## Application for a Non-Material Amendment Following a Grant of Planning Permission

Erection of a single storey rear extension infill.

78416/APP/2023/3538

Increase the size of the approved extension from 4.220m to 4.500m.

APPROVED AND PROPOSED PLANS

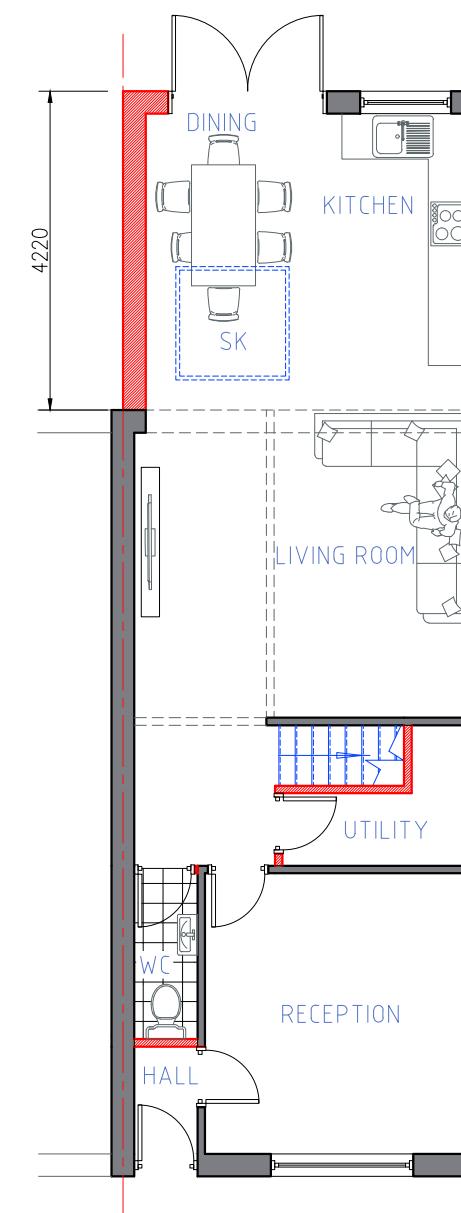
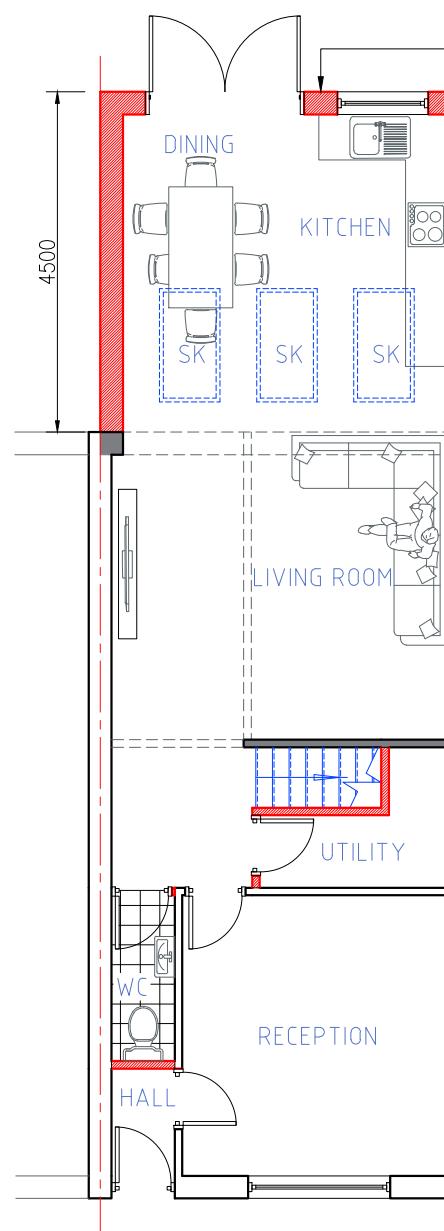
Non-material amendment application is needed to increase the approved size of the extension from 4.220m to 4.500m.

The ground floor garden facing wall needs to be rebuilt with a cavity wall to comply with the latest building regulation requirements.
